ENG-PUDSP20001-R1-PUDSP-Redlines Summary_Markup Summary

SITE PLAN
P4 4 OF 10

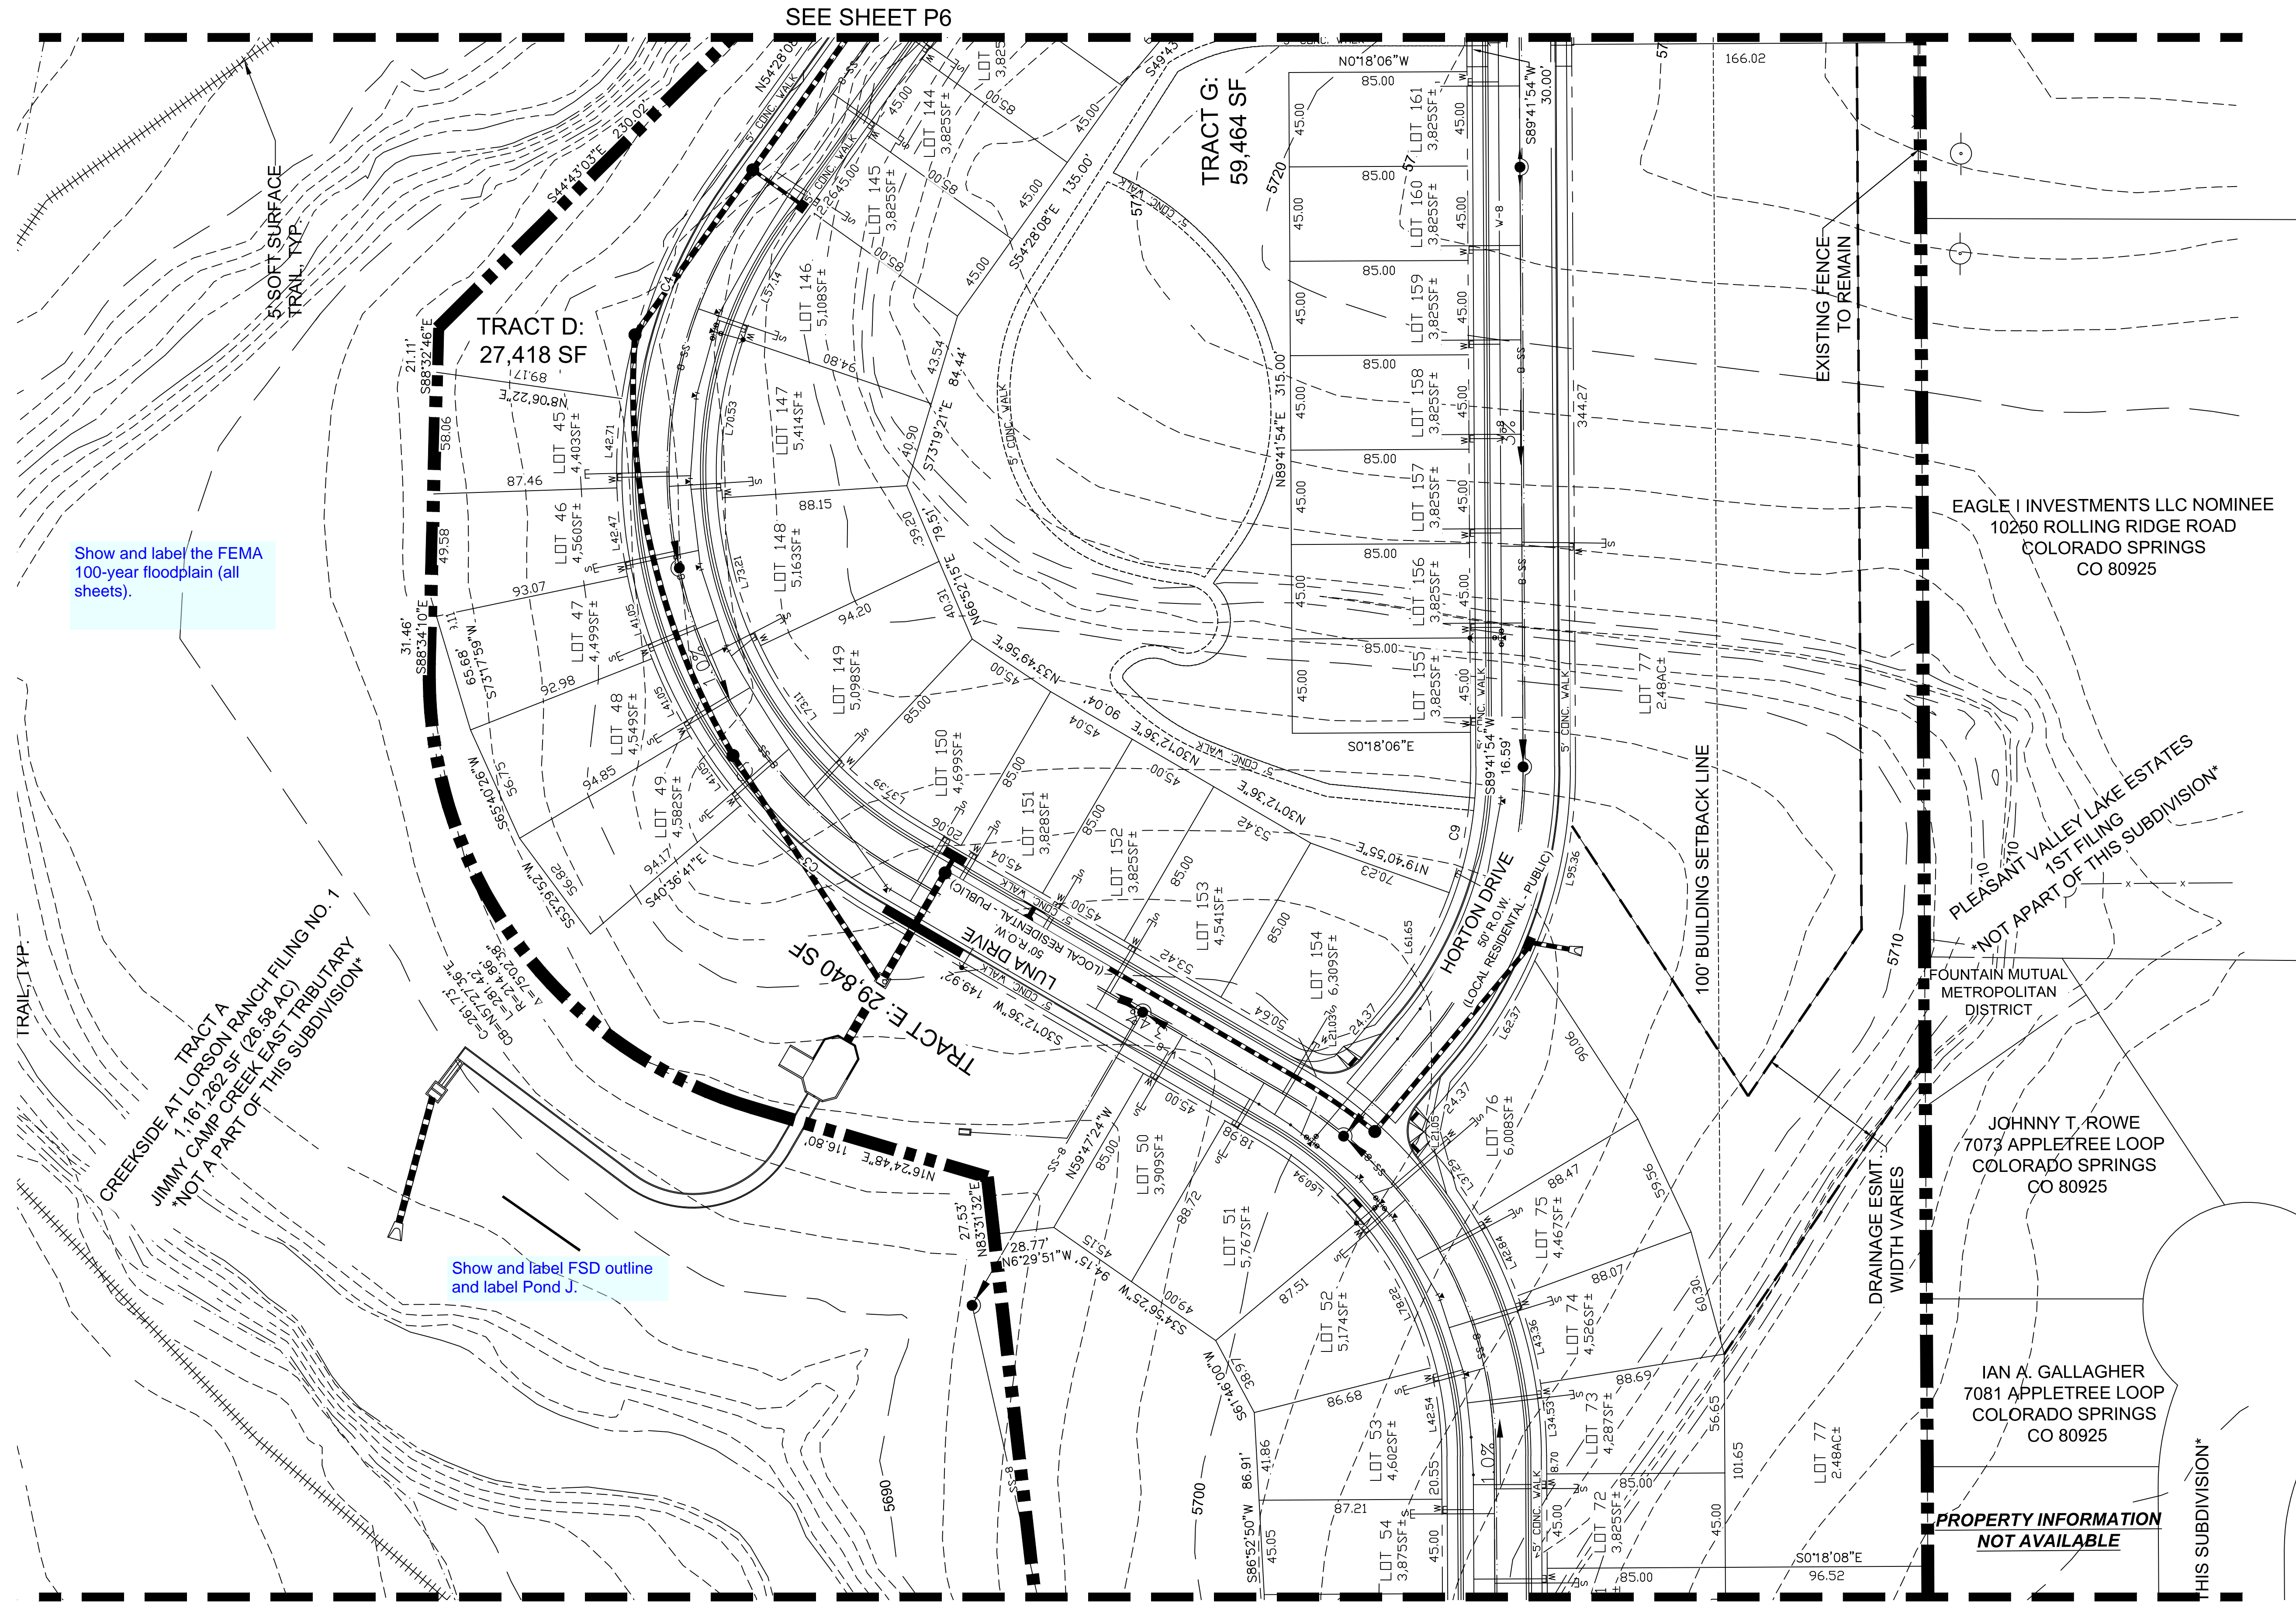
Outline and label ponding area

Is drainage easement in the right place?

label if FUTURE DEVELOPEmnt

where are lot lines and dimensions for large lots?

Show and label the 100-year floodplain.

SITE PLAN
P5 5 OF 10

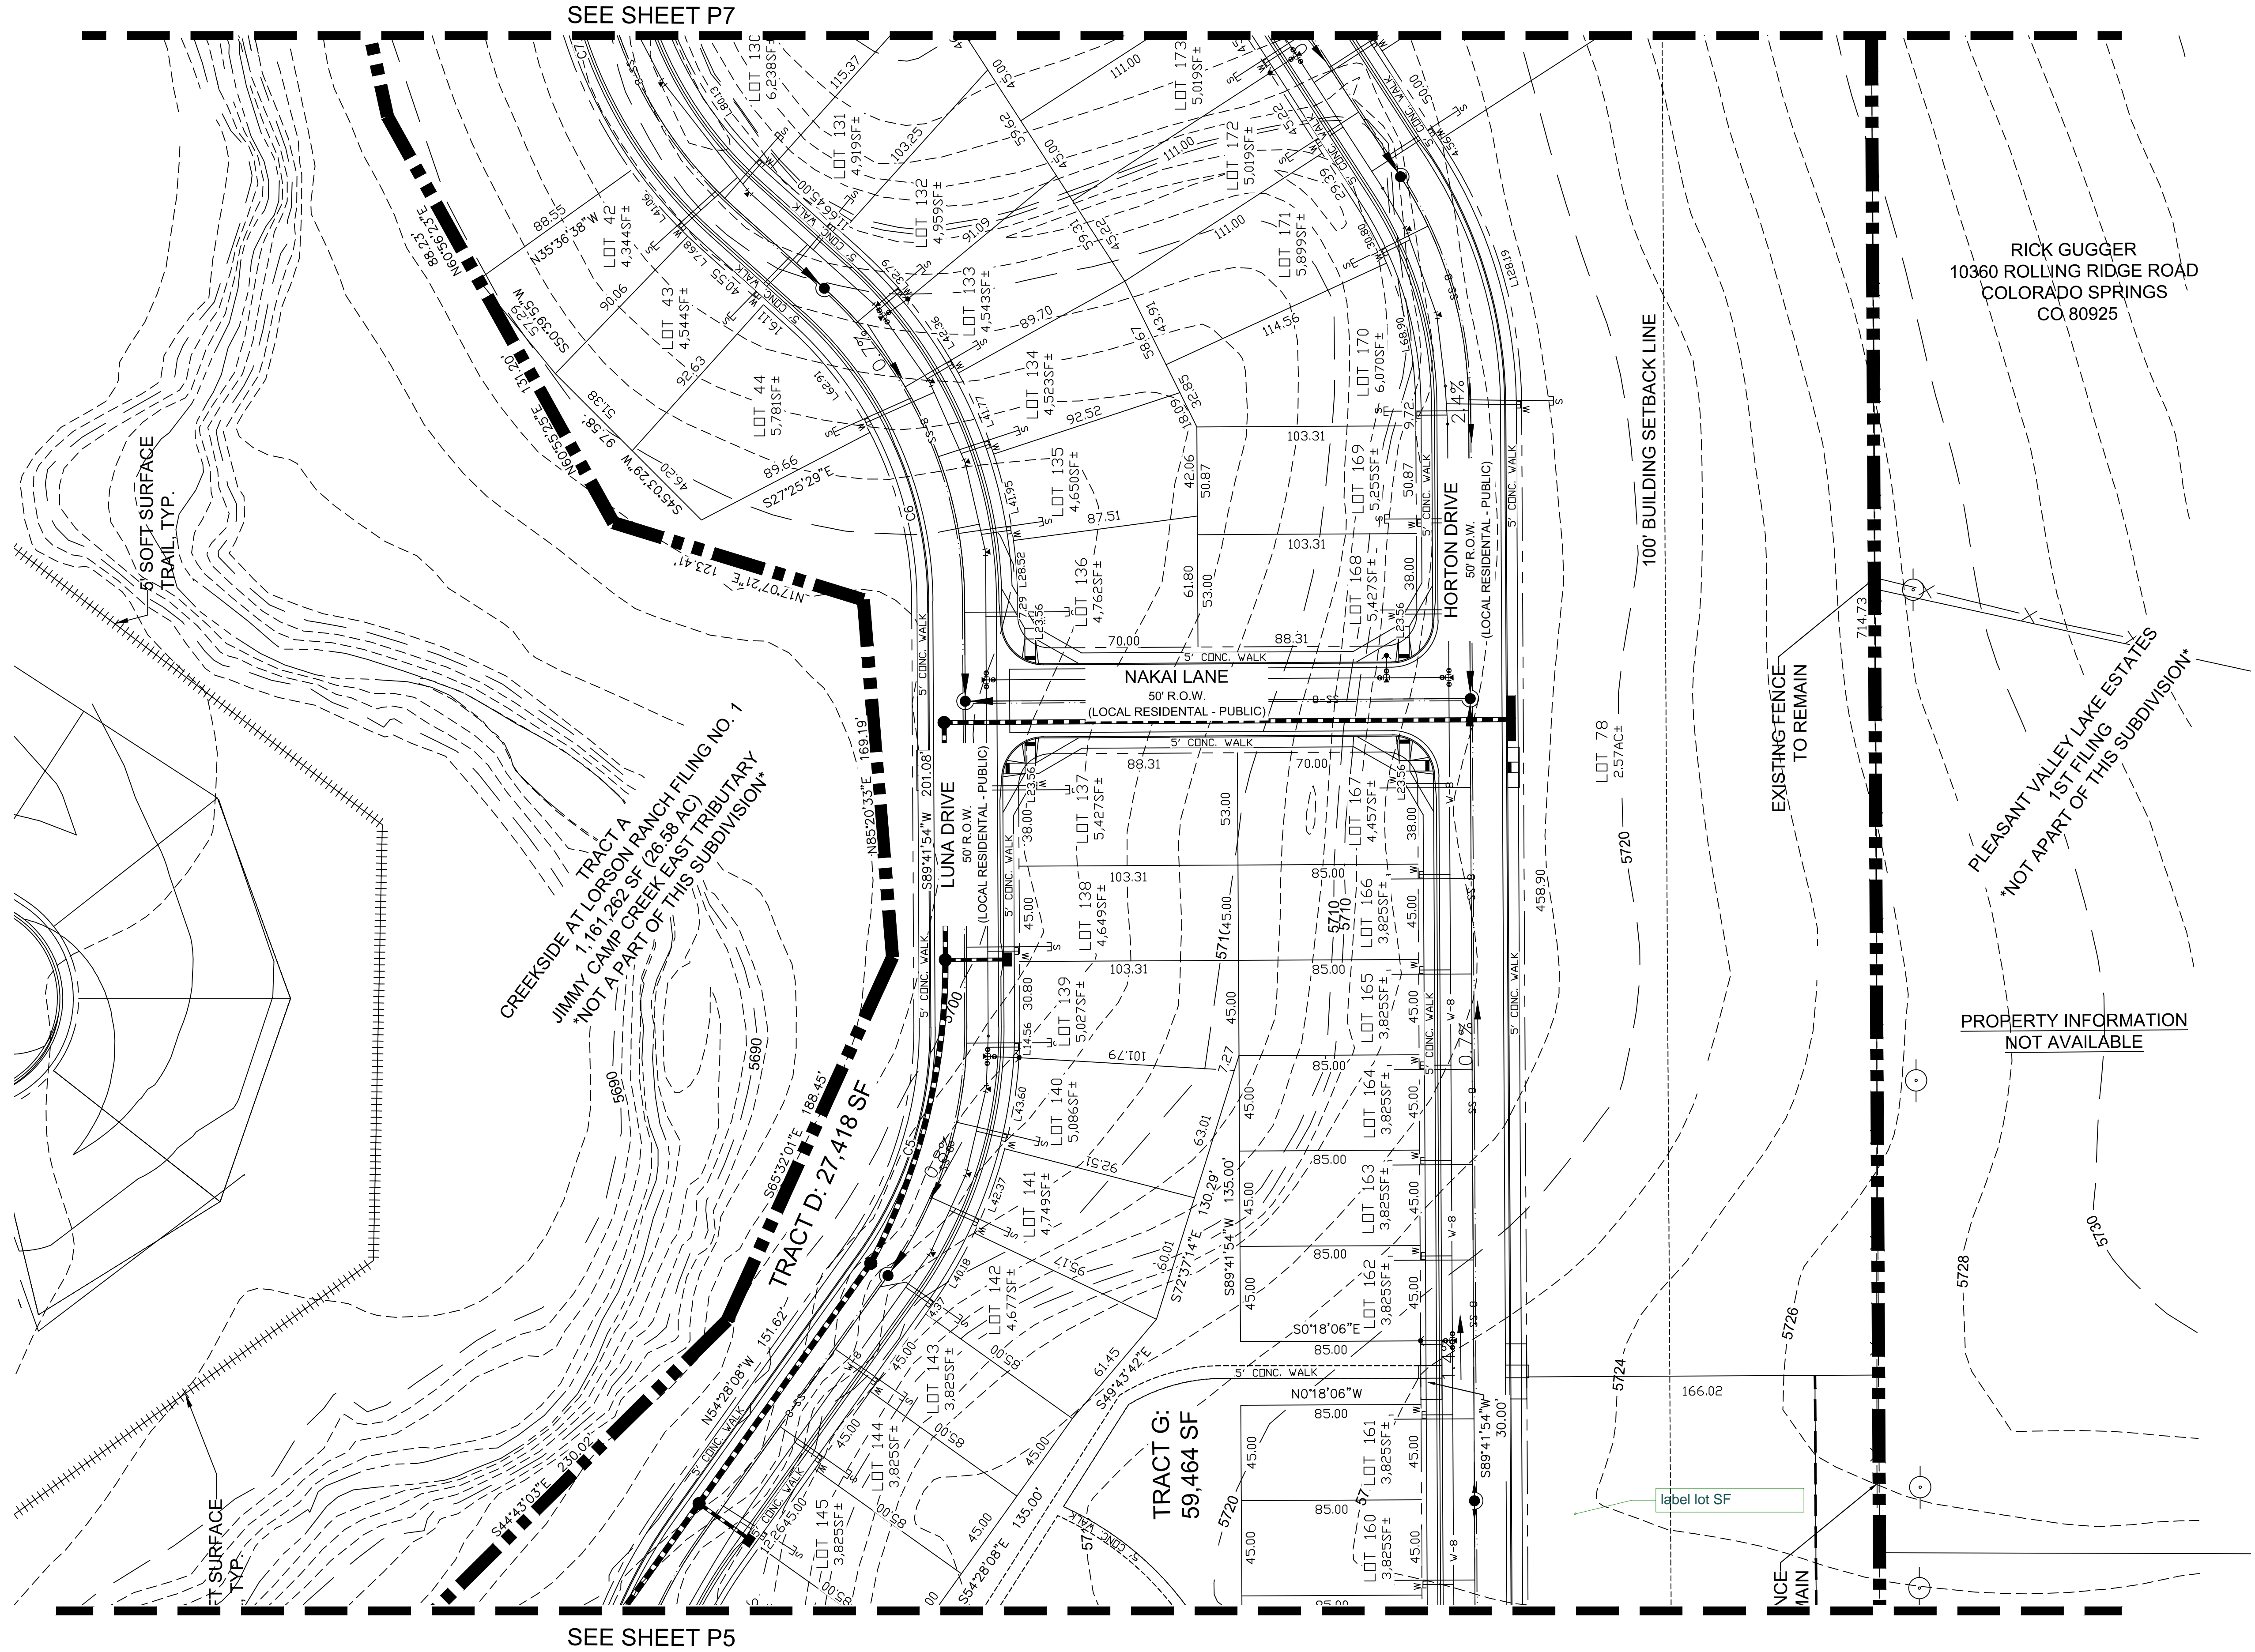
Show and label FSD outline and label Pond J.

Show and label the FEMA 100-year floodplain (all sheets).

SITE PLAN
P8 8 OF 10

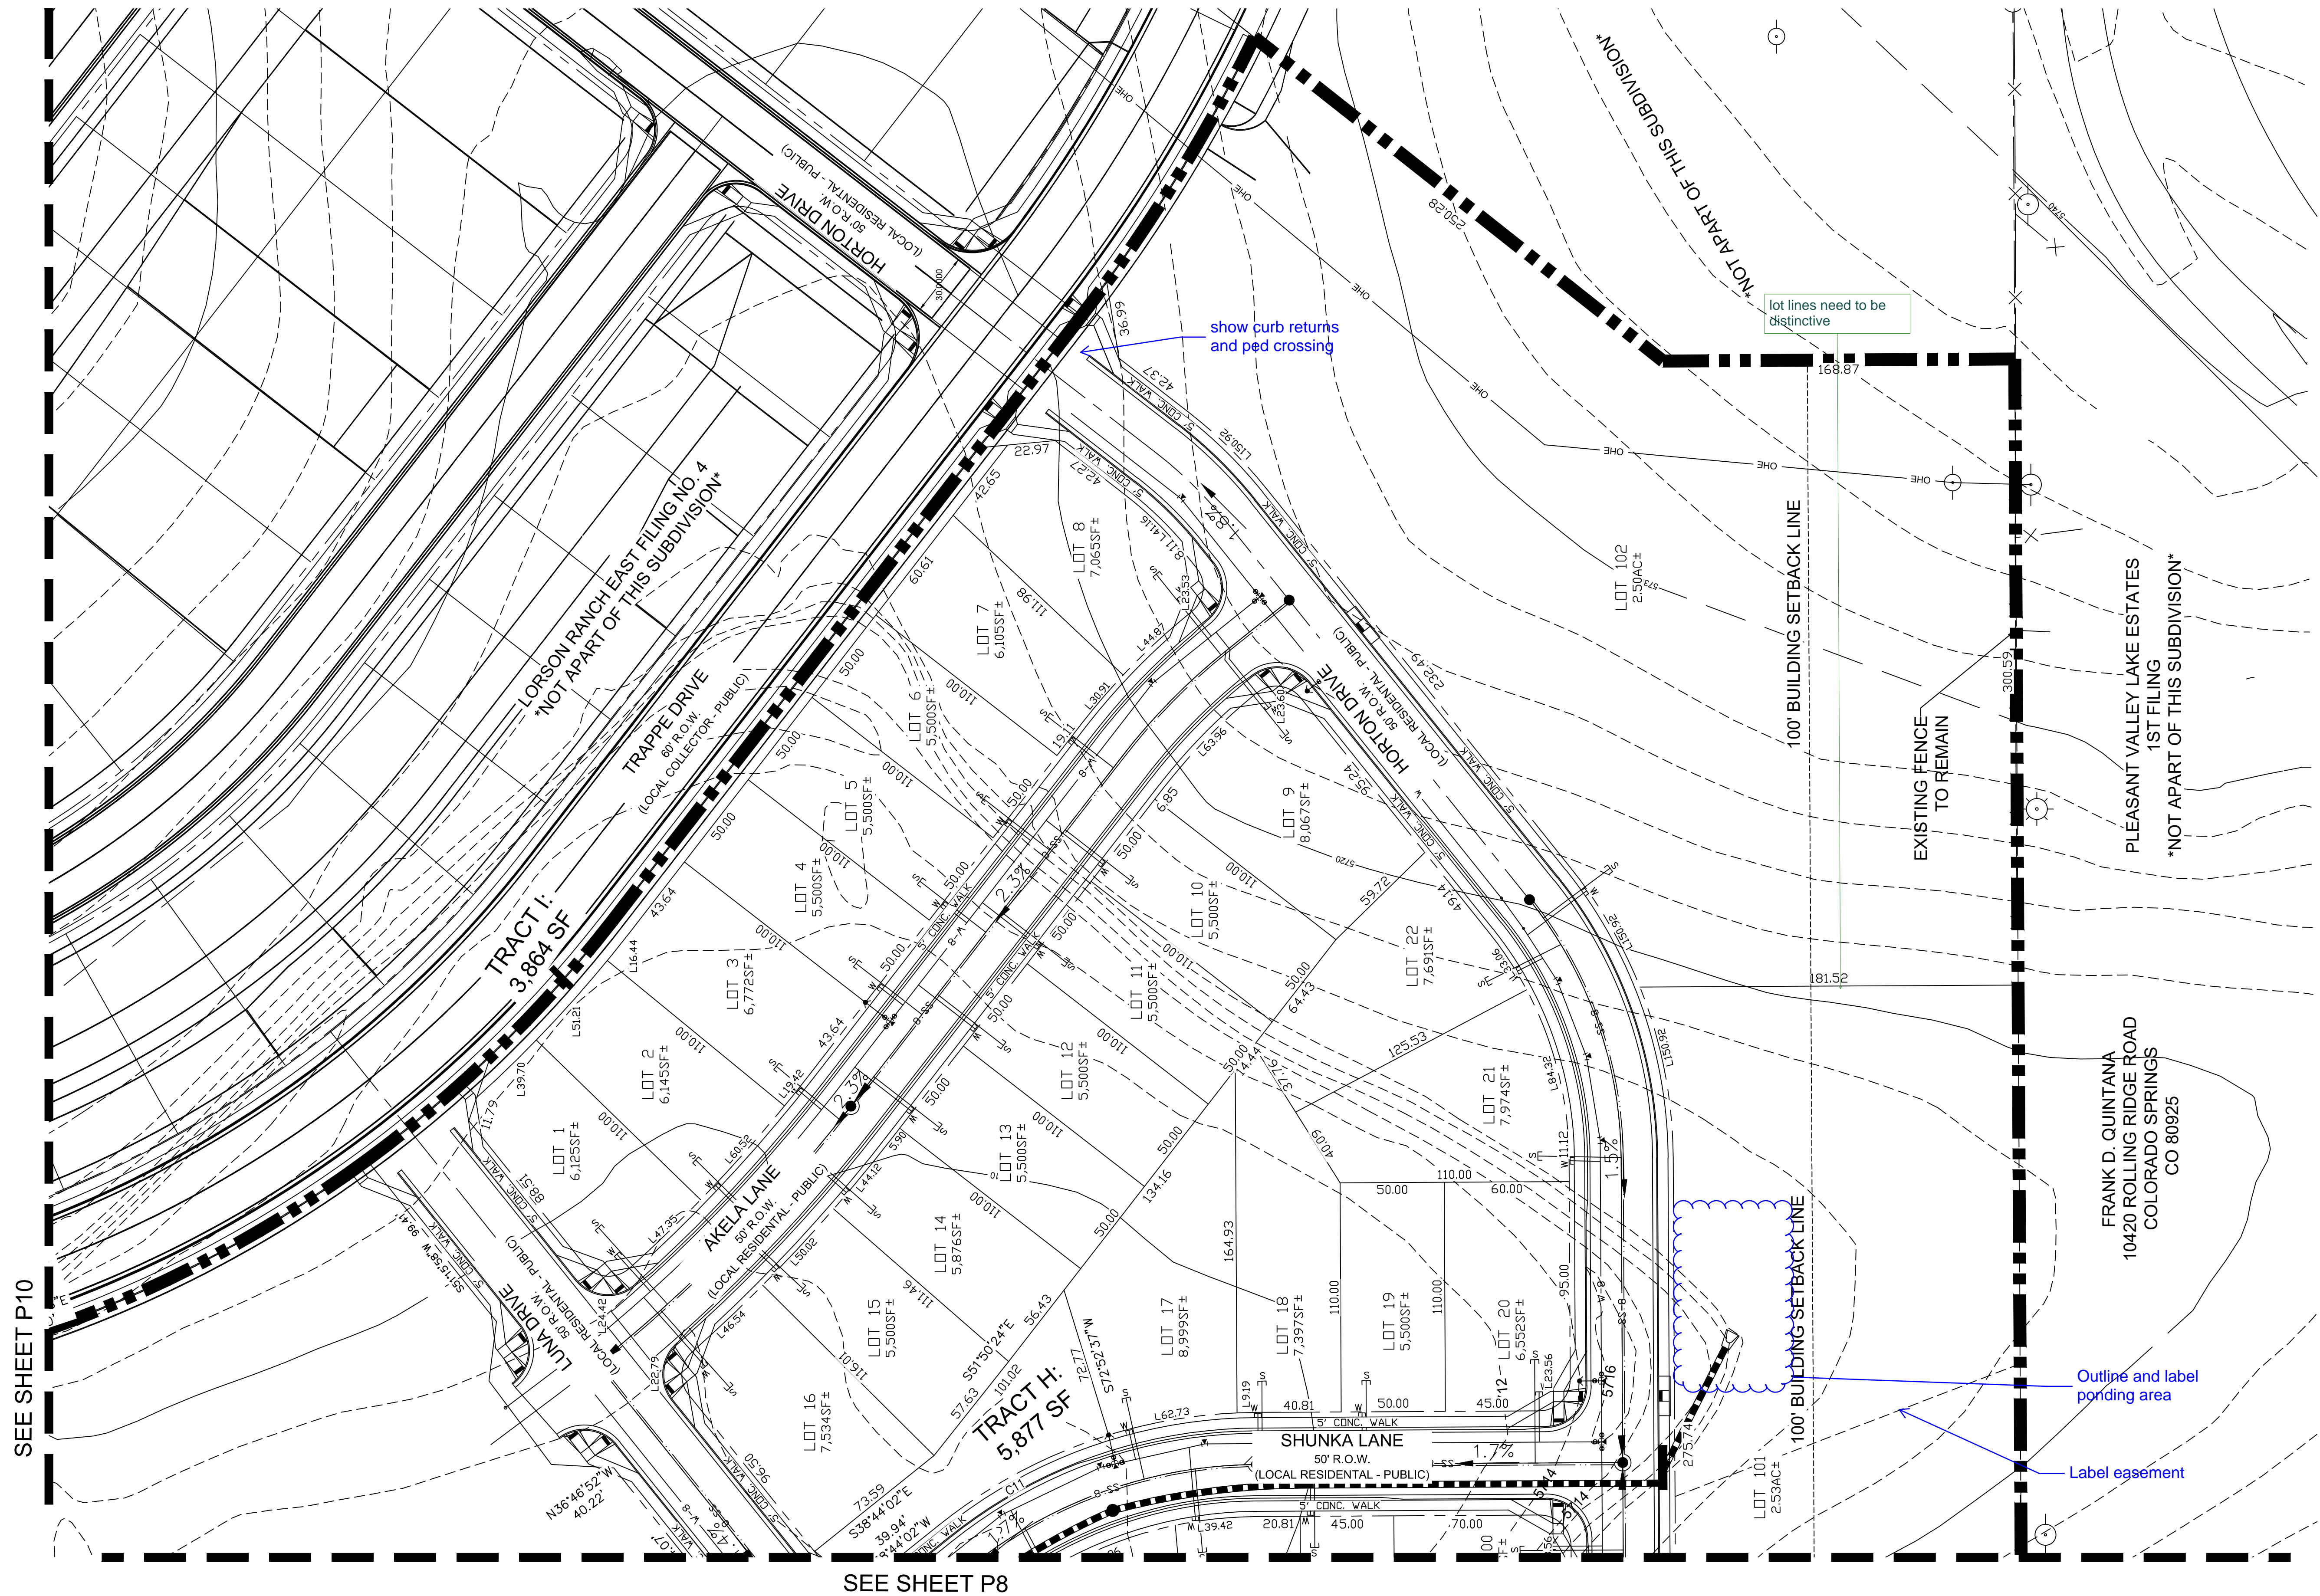
Label line bearing

label this

label lot SF
